| Report title:                    | Designers response to Stage 1 Road Safety Audit, Pagham South Local Centre |
| Date:                            | 14 <sup>th</sup> February 2022                                             |
| Document reference and revision: | 2152/RSA/DR/02                                                             |

A Stage 1 Road Safety Audit (ref: 211206) was produced by Avon Traffic & Safety Services on 14<sup>th</sup> February 2022 with regards to the proposed spine road and local centre access at land west of Pagham Road, Pagham, West Sussex. The scope of the survey also included an indicative access to a future school with associated waiting and loading restrictions (double yellow lines and school keep clear markings), the access to the school and associated road markings will be confirmed as part of a forthcoming planning application for the school.

SPINE ROAD AND
LOCAL CENTRE ACCESS

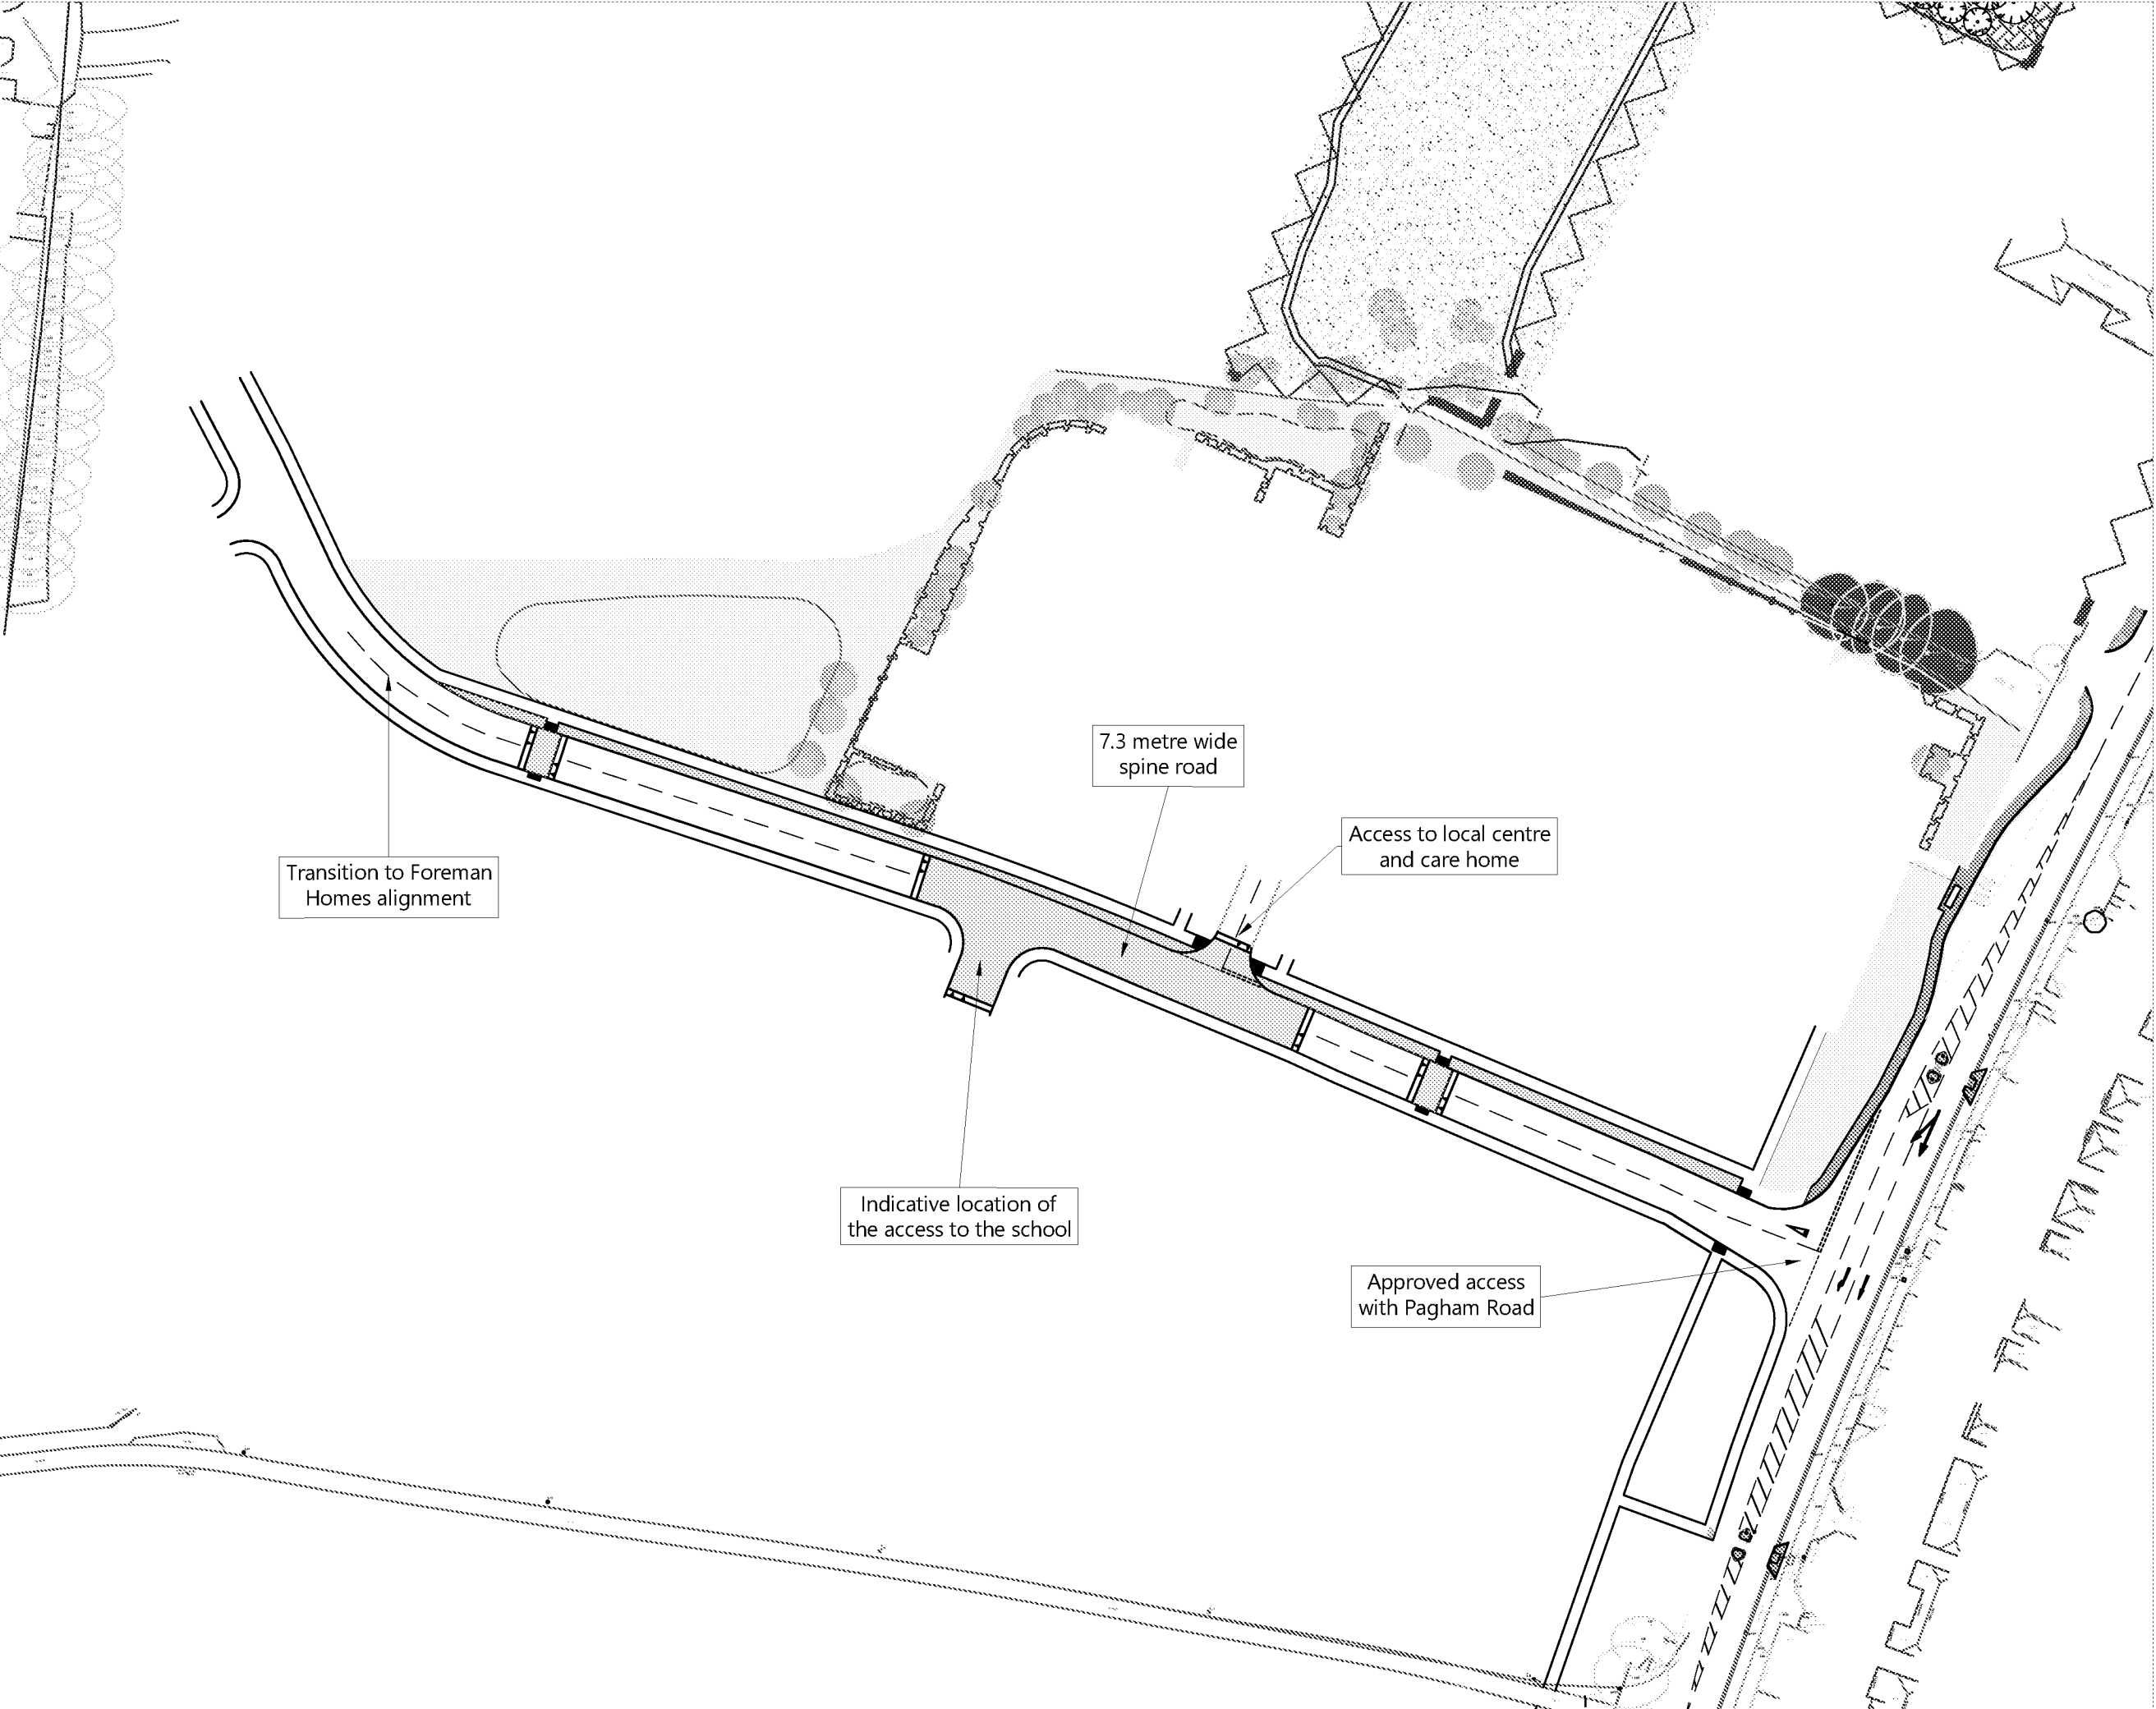
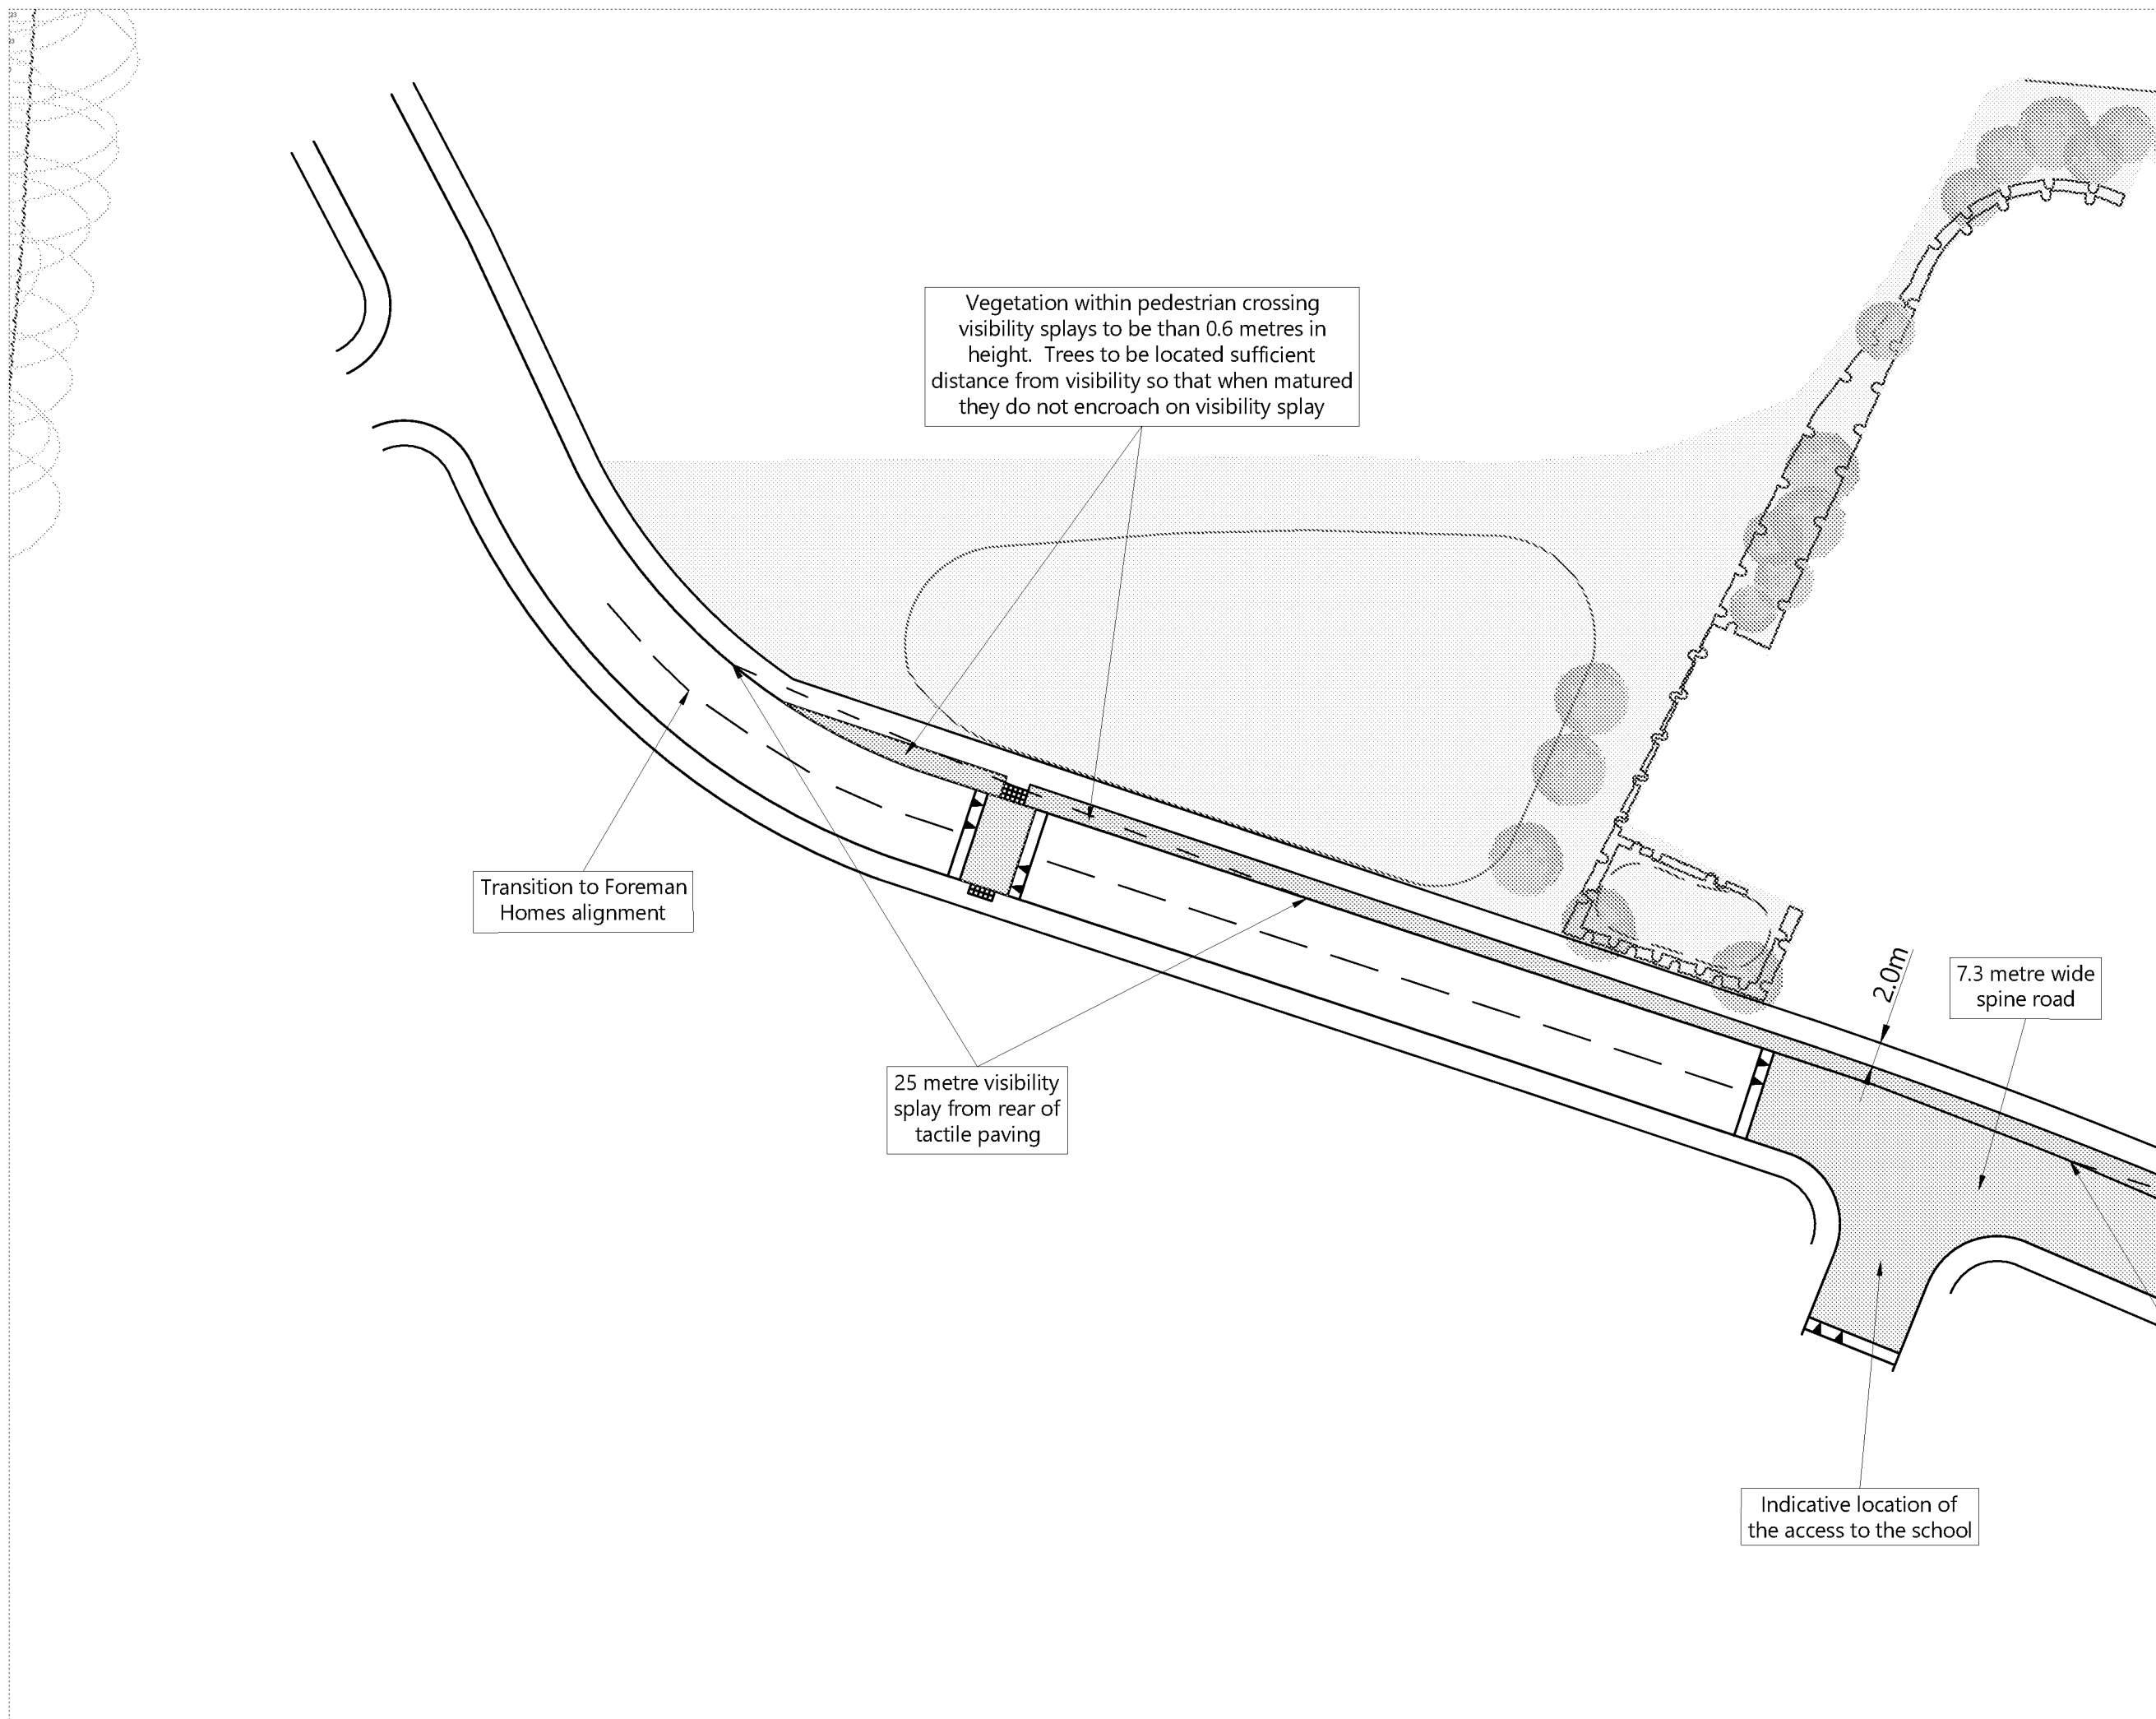
| RSA issue                                                                                                                                                                                                                                                                                                                    | RSA recommendation                                                                               | Design response                                                                                                                                                                                                       | Organisation | Overseeing Organisation response                                                                                                                                                                                                                               | Agreed RSA action                                                                |
|------------------------------------------------------------------------------------------------------------------------------------------------------------------------------------------------------------------------------------------------------------------------------------------------------------------------------|--------------------------------------------------------------------------------------------------|-----------------------------------------------------------------------------------------------------------------------------------------------------------------------------------------------------------------------|--------------|----------------------------------------------------------------------------------------------------------------------------------------------------------------------------------------------------------------------------------------------------------------|----------------------------------------------------------------------------------|
| <p>Speed table at west end of site</p> <p>It is not clear if the spine road will be a bus route, however if it is, the proposed speed table is not bus-friendly, as it is not long enough for a bus to completely mount the table before leaving the far side. The resultant motion could cause injury to bus passengers</p> | If the spine road is to be a bus route, extend the speed table to a minimum length of 6.0 metres | Accepted – It is not yet known if the spine road will form a bus route. However, there are no material downsides in providing the lengthened raised table as suggested and this is now shown on the updated drawings. |              | It's considered unlikely that the internal road support a regular bus service; this possibility hasn't been identified through the agreed design principles. The designer has nevertheless agreed to the auditors recommendation.. This is acceptable to WSCC. | The speed table referred is to be extended in length to a minimum of 6.0 metres. |

| RSA problem                                                                                                                                                                                                                                                                                                                                                                                                                         | RSA recommendation                                          | Design Organisation response                                                                                                                                                                                                                                                                                                                                                                      | Overseeing Organisation response                                                                                                                              | Agreed RSA action                                                                                                                     |
|-------------------------------------------------------------------------------------------------------------------------------------------------------------------------------------------------------------------------------------------------------------------------------------------------------------------------------------------------------------------------------------------------------------------------------------|-------------------------------------------------------------|---------------------------------------------------------------------------------------------------------------------------------------------------------------------------------------------------------------------------------------------------------------------------------------------------------------------------------------------------------------------------------------------------|---------------------------------------------------------------------------------------------------------------------------------------------------------------|---------------------------------------------------------------------------------------------------------------------------------------|
| <p>School Keep Clear markings, south side of spine road</p> <p>The School Keep Clear markings are shown to the east of the school entrance only, meaning that parents' vehicles will legally be able to stop and wait to pick up/drop off students to the immediate west of the entrance. In this position they could obscure pedestrians crossing south to north, such that they would risk being struck by westbound vehicles</p> | Add School Keep Clear markings to west of the school access | <p>Accepted – School Keep Clear markings have been provided to the west of the indicative school access.</p> <p>It should be noted that the school access shown is indicative and when the school application is brought forward the access will be designed in detail. This will include the extents of road markings to ensure the continued safe operation of the spine road and accesses.</p> | <p>The Designers response is noted and agreed.</p> <p>It's recognised that the school access and associated road markings may be amended at a later time.</p> | No further action required at this stage. The extent of School Keep Clear markings should be reviewed as part of the detailed design. |

| RSA problem                                                                                                                                                                                                                                                                                                                                                                                                                                                                                                                                                 | RSA recommendation                                                                                                             | Design Organisation response                                                                                                                                 | Overseeing Organisation response                                                                                                                                                          | Agreed RSA action                                                                                                        |
|-------------------------------------------------------------------------------------------------------------------------------------------------------------------------------------------------------------------------------------------------------------------------------------------------------------------------------------------------------------------------------------------------------------------------------------------------------------------------------------------------------------------------------------------------------------|--------------------------------------------------------------------------------------------------------------------------------|--------------------------------------------------------------------------------------------------------------------------------------------------------------|-------------------------------------------------------------------------------------------------------------------------------------------------------------------------------------------|--------------------------------------------------------------------------------------------------------------------------|
| <p>Spine Road, north side between proposed waiting restrictions and the bend at west end of audit site</p> <p>It is possible that school parking will extend along the north side of the spine road from the end of the proposed restrictions, over the speed table (which is an informal pedestrian crossing point) and around the inside of the bend. Parked vehicles in this area will obstruct the view to the west of pedestrians waiting to cross north to south on the speed table, such that they would risk being struck by eastbound vehicles</p> | Extend the waiting restrictions westward from the proposed end point, to a point adjacent to the next junction around the bend | Accepted – Waiting restrictions have been provided through the northern side of the pedestrian crossing and its visibility splays to the west of the school. | Although the Developer's strategy for managing school related parking is currently unclear, which may in turn affect the extent of waiting restrictions, the Designers response accepted. | No further action is required at this stage. The waiting restrictions should be implemented through the detailed design. |

| RSA problem                                                                                                                                                                                                                                                                                                                                                                                                                    | RSA recommendation                                                                                                            | Design Organisation response                                                                                                                                 | Overseeing Organisation response            | Agreed RSA action                                                                                                        |
|--------------------------------------------------------------------------------------------------------------------------------------------------------------------------------------------------------------------------------------------------------------------------------------------------------------------------------------------------------------------------------------------------------------------------------|-------------------------------------------------------------------------------------------------------------------------------|--------------------------------------------------------------------------------------------------------------------------------------------------------------|---------------------------------------------|--------------------------------------------------------------------------------------------------------------------------|
| <p>Speed table at west end of site</p> <p>It is possible that school parking will extend along the south side of the spine road from the end of the proposed restrictions, over the speed table (which is an informal pedestrian crossing point). If this occurs, pedestrians crossing south to north on the speed table will be obscured by parked vehicles, such that they would risk being struck by westbound vehicles</p> | Provide a short length of waiting restrictions on the south side of the spine road, to protect the speed table/crossing point | Accepted – Waiting restrictions have been provided through the southern side of the pedestrian crossing and its visibility splays to the west of the school. | The Designers response is noted and agreed. | No further action is required at this stage. The waiting restrictions should be implemented through the detailed design. |
